The Planning Act 2008

Section 55 Acceptance of Applications

Section 55 Application Checklist¹

Section 55(2) Acceptance of Applications				
1	Within 28 days (starting day after receipt) the Secretary of State must decide whether or not to accept the application.	Date received	28 day due date	Date of decision
		27 June 2018	25 July 2018	23 July 2018
Section 55(3) – the Secretary of State may <u>only</u> accept an application if the Secretary of State concludes that:-		Planning Inspectorate Comments		
s55(3)(a) and s55(3)(c) It is an application for an order granting development consent				
2	Is the development a nationally significant infrastructure project ² (NSIP) (or does it form part of an NSIP); and does the application state on the face of it that it is an application for a development consent order ³ (DCO) under the Planning Act 2008 (the PA2008), or equivalent words? Does the application specify the development to which it relates (i.e. which category or categories in ss14-30 does the application scheme fall)? If the development does not fall within the categories in	<p>Yes</p> <p>The proposed development set out in Schedule 1 of the draft DCO (dDCO) (Doc 3.1) is a Nationa

### Land Plan (Onshore) - Sheet 0

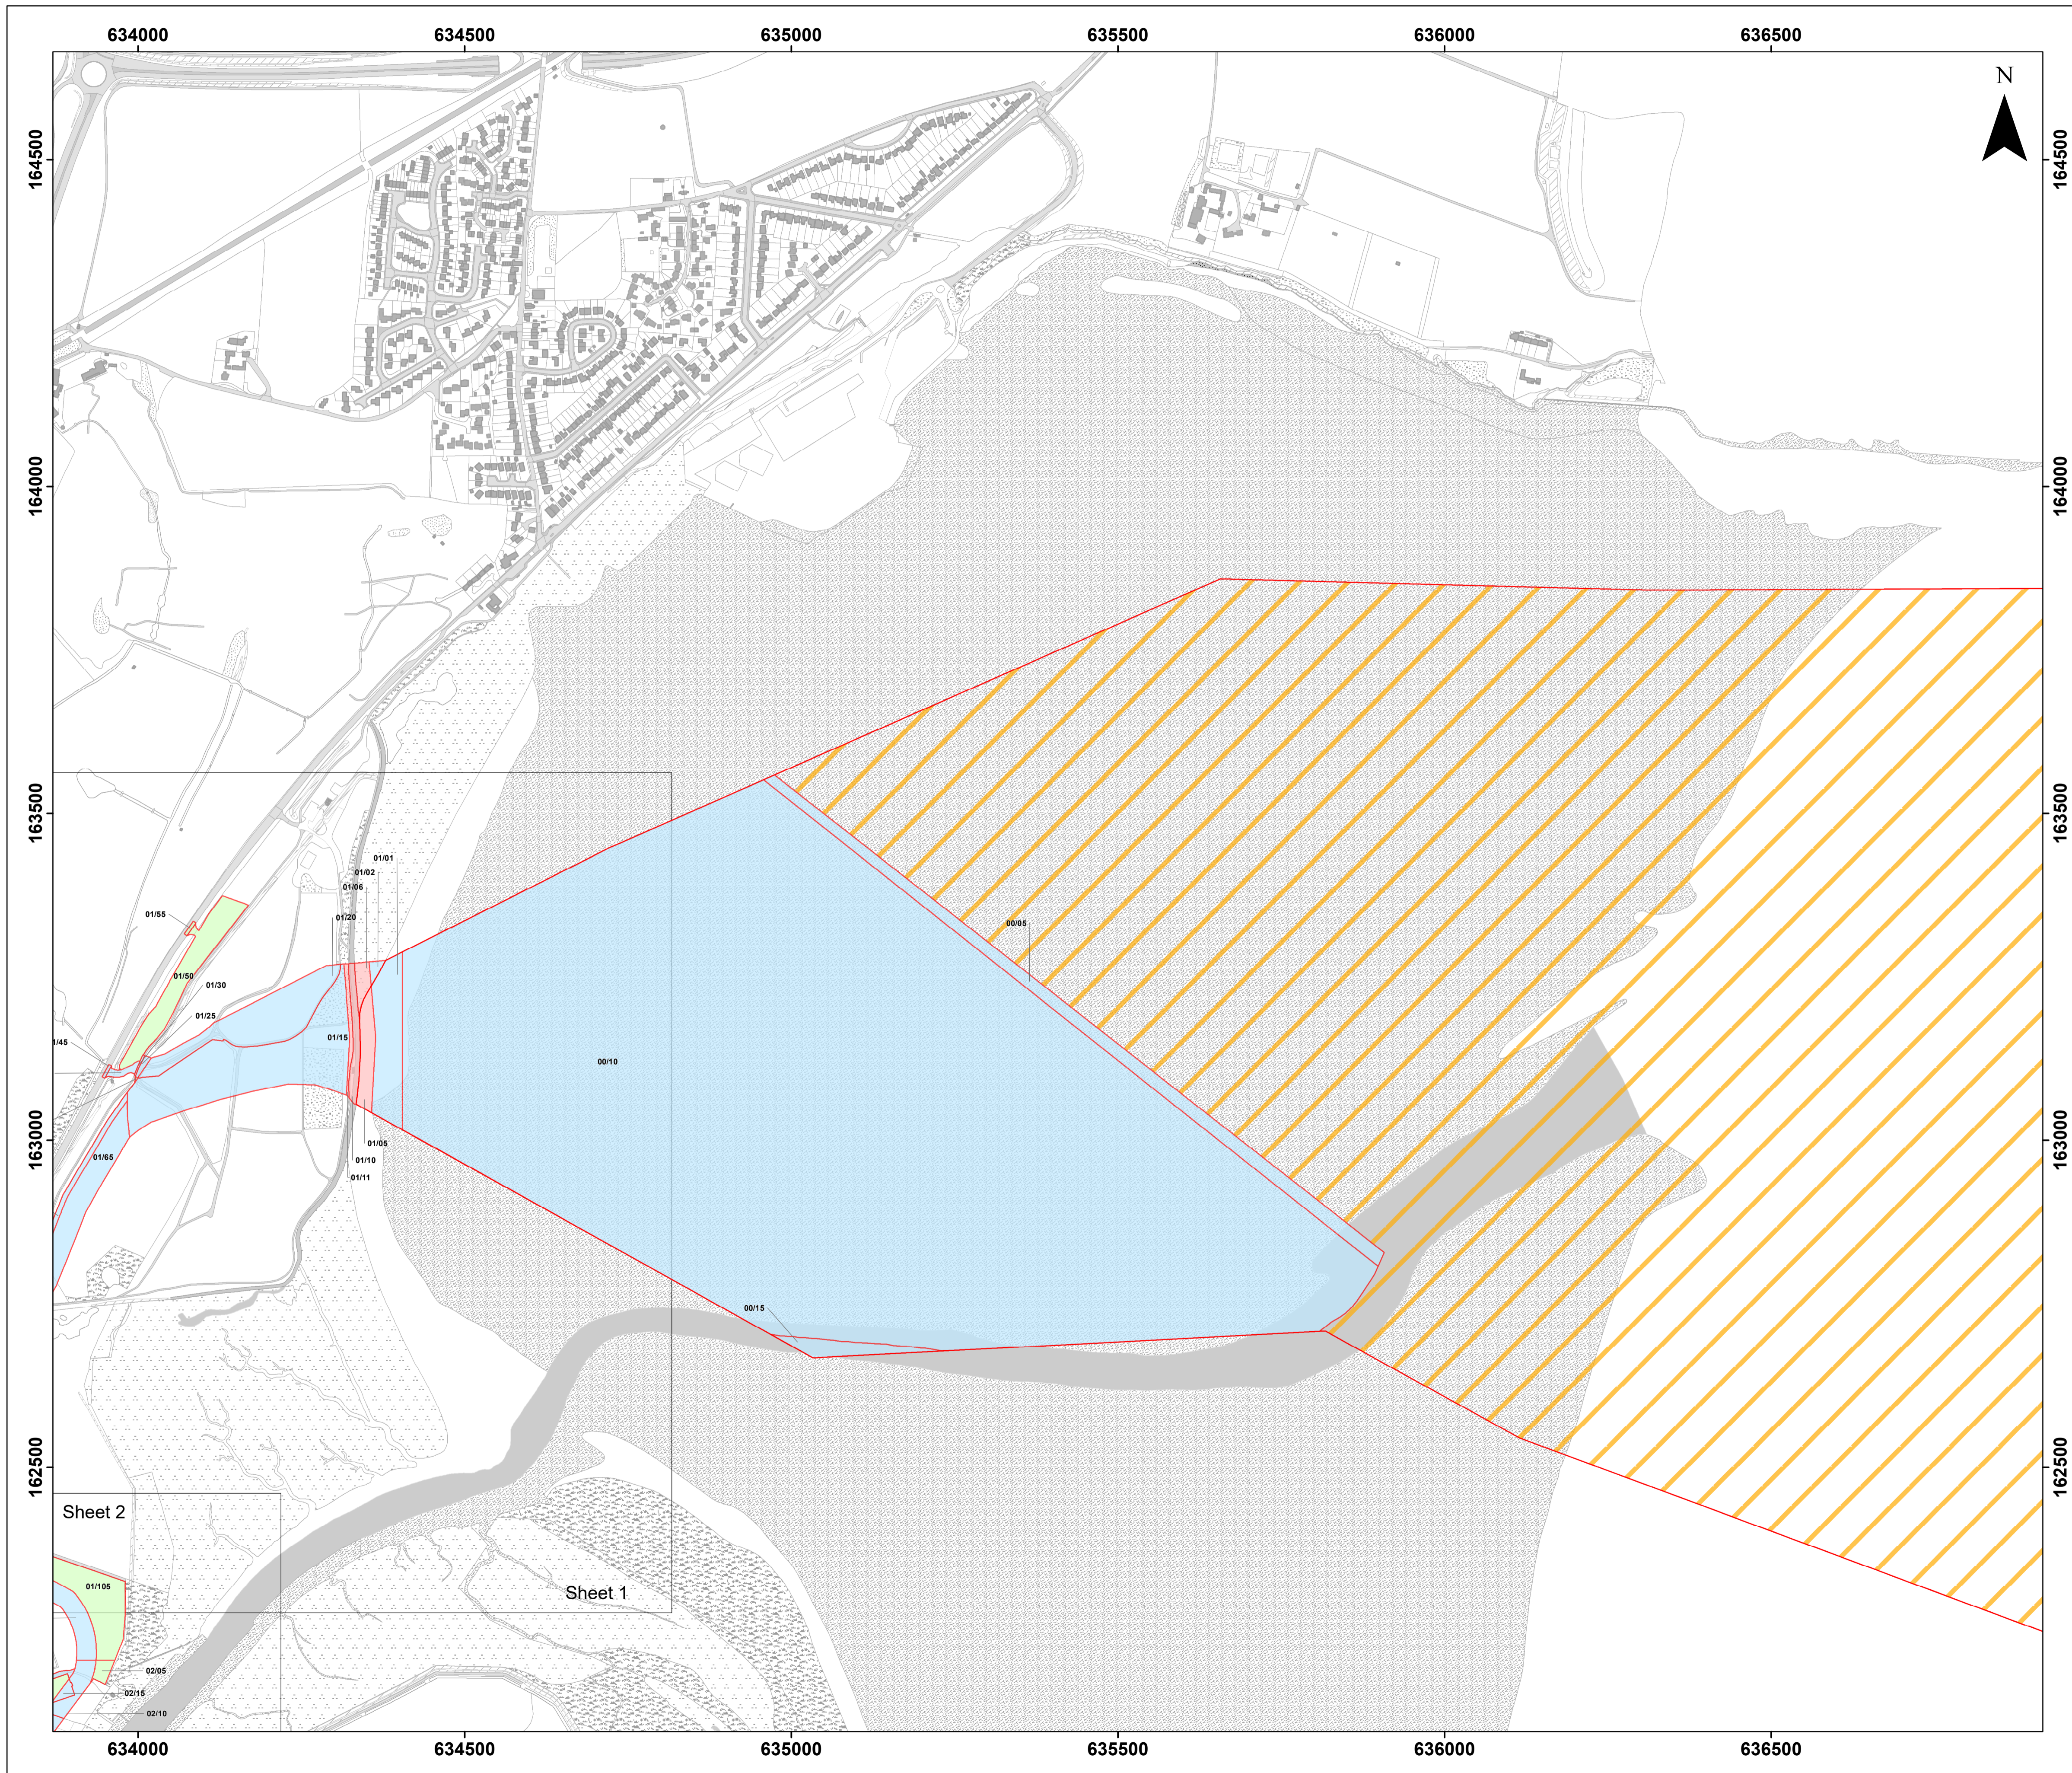
- In the legend 'Cable route options' does not describe what rights are being sought.
- No landmarks or road names are identified on the land plans
- The scale is not in compliance with Regulation 5(4A) of the APFP Regulations, for the onshore plan sheet 0

[s51 advice](#) has been provided to the Applicant to remedy the issues raised in Box 30.

**Land Plan (Onshore) -  
Sheet 1**  
 Document reference: 2.3  
 APFP Regulation: 5(2)(i)

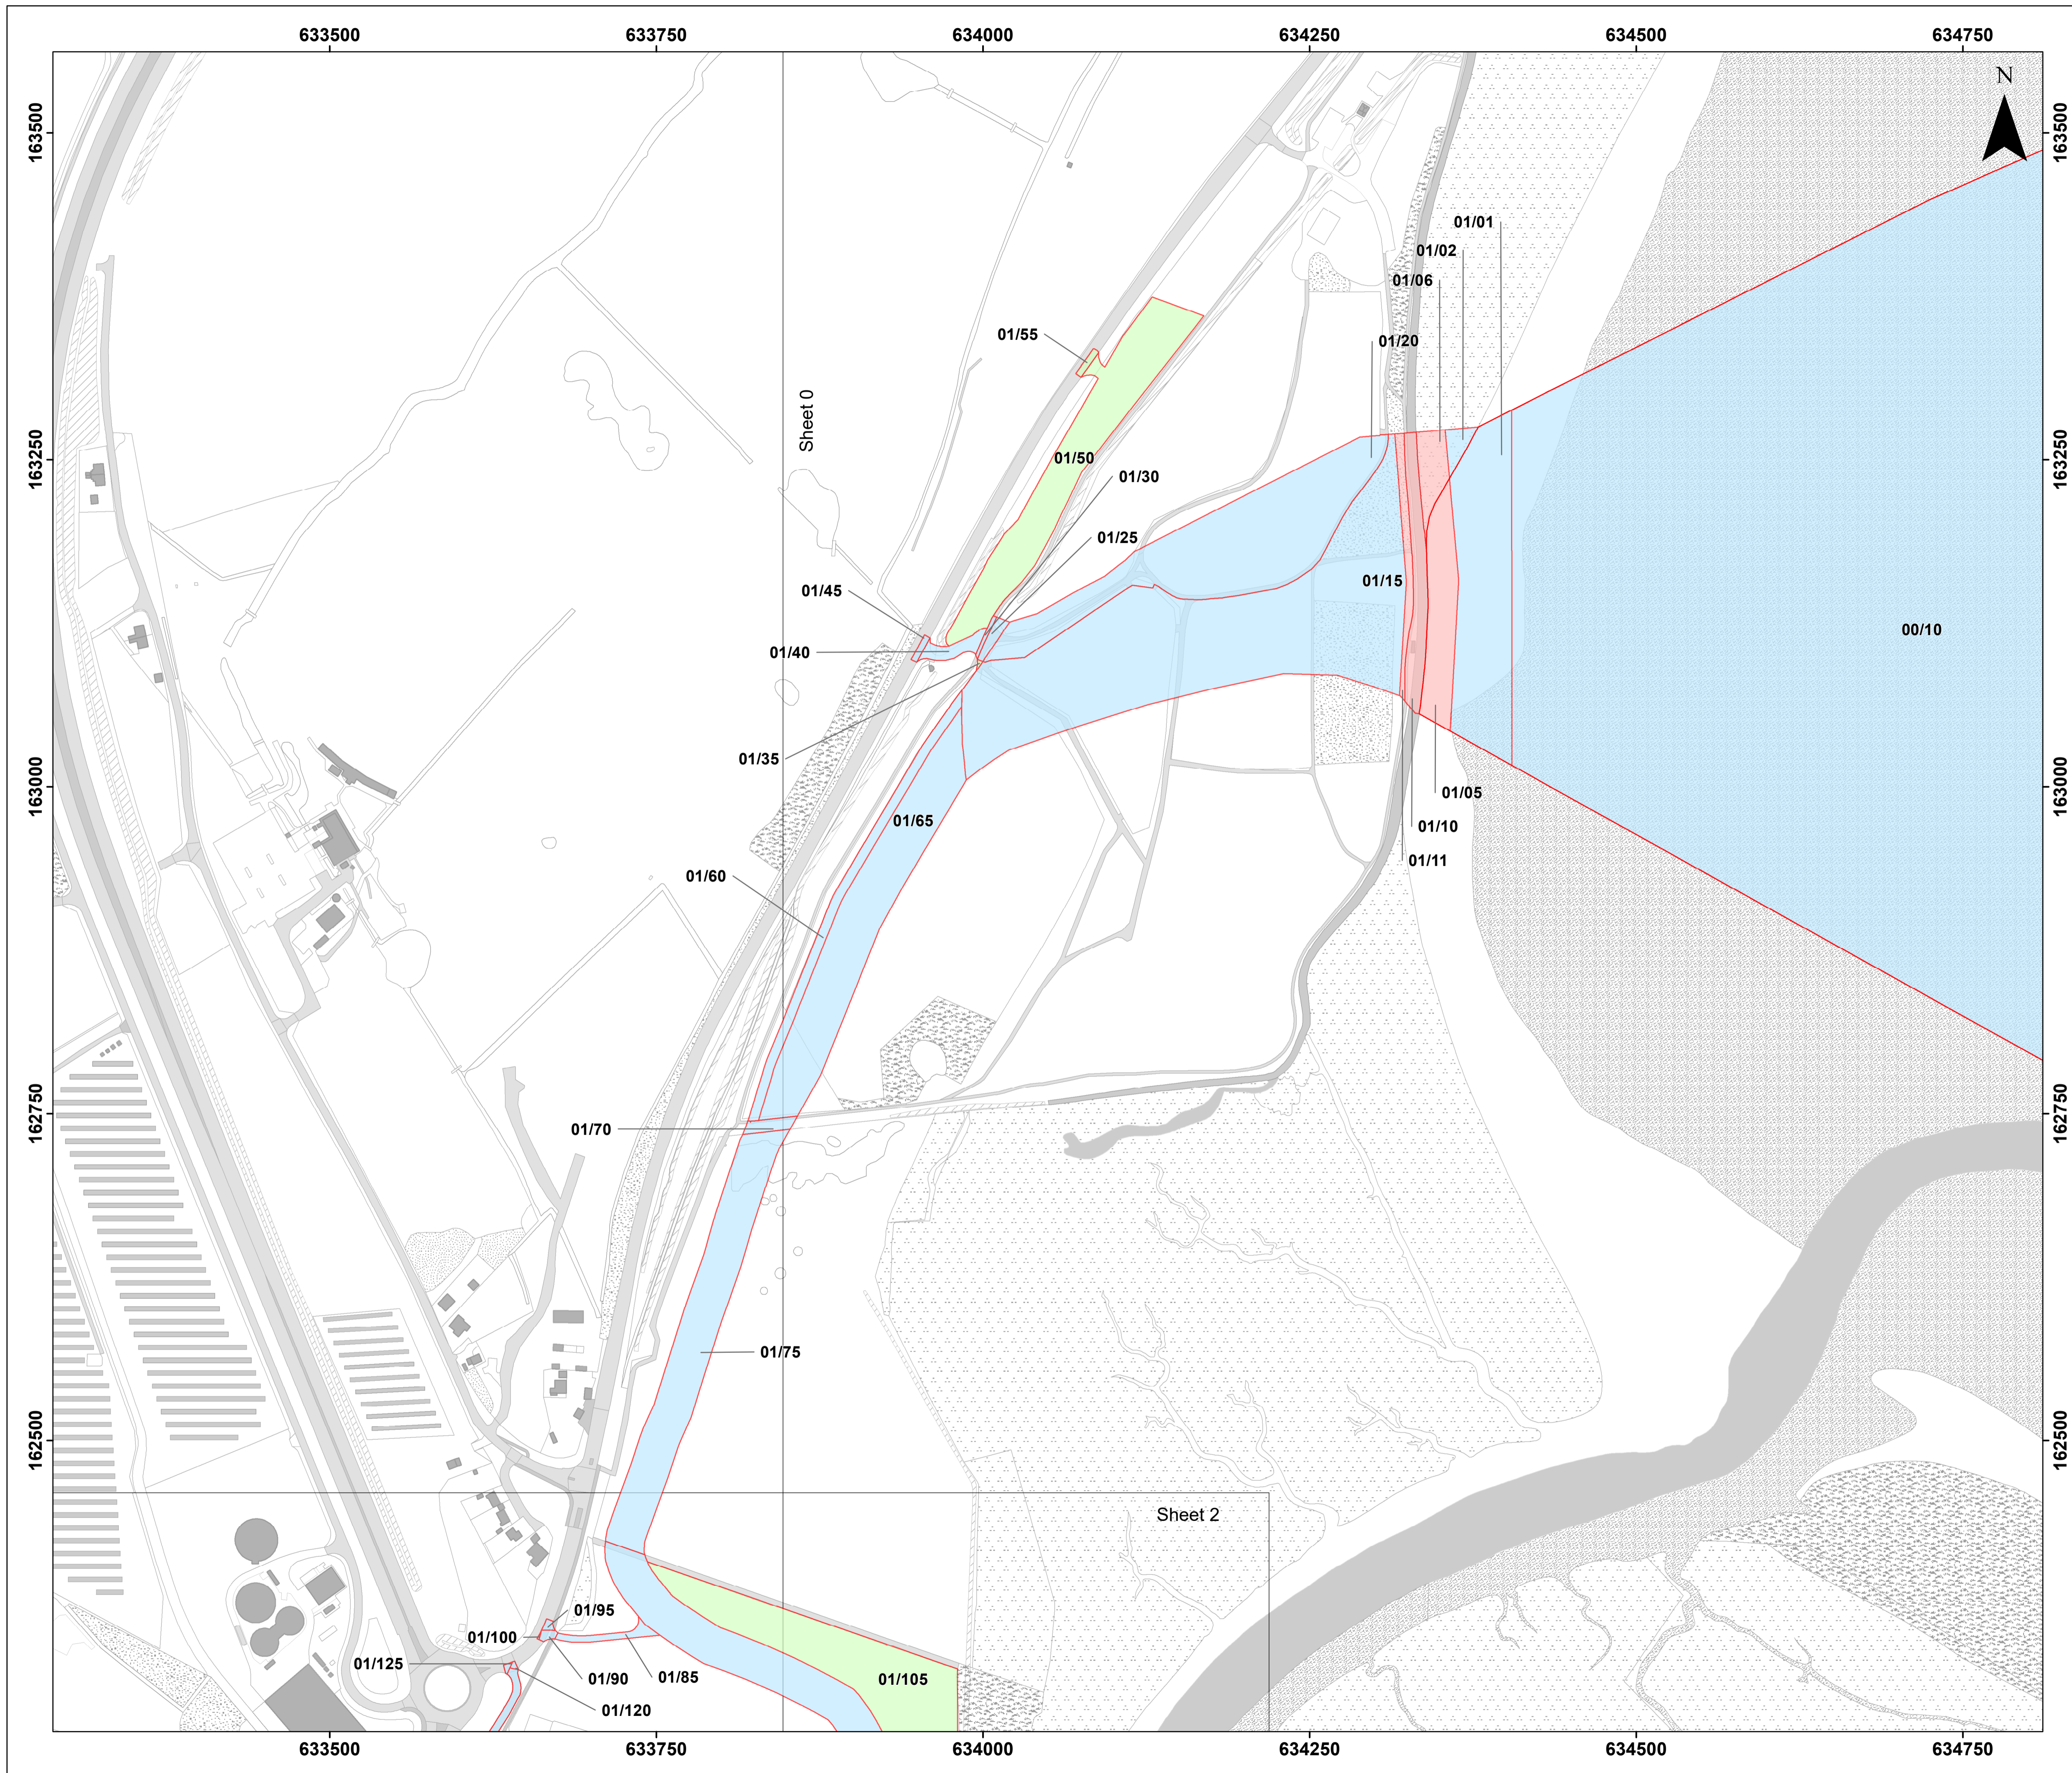
- Plot 01/55 is coloured green on the land plan, showing it is temporary possession and is included in Schedule 7 of the DCO (Land of which Temporary Possession may be taken) and not in Schedule 5 (Land in which only New Rights etc., may be acquired). However the Book of Reference refers to new rights.

- Plot 01/105 is coloured green on the land plan, showing it is temporary possession and is included in Schedule 7 of the DCO (Land of which Temporary Possession may be taken) and not in Schedule 5 (Land in which only New Rights etc., may be acquired). However the Book of Reference refers to new rights.

- The area containing plot 01/100 on sheet 1 of the Land Plan Onshore could benefit from an inset.
- Plots 01/80 and 01/115 are not identified on sheet 1 of the Land Plan Onshore.
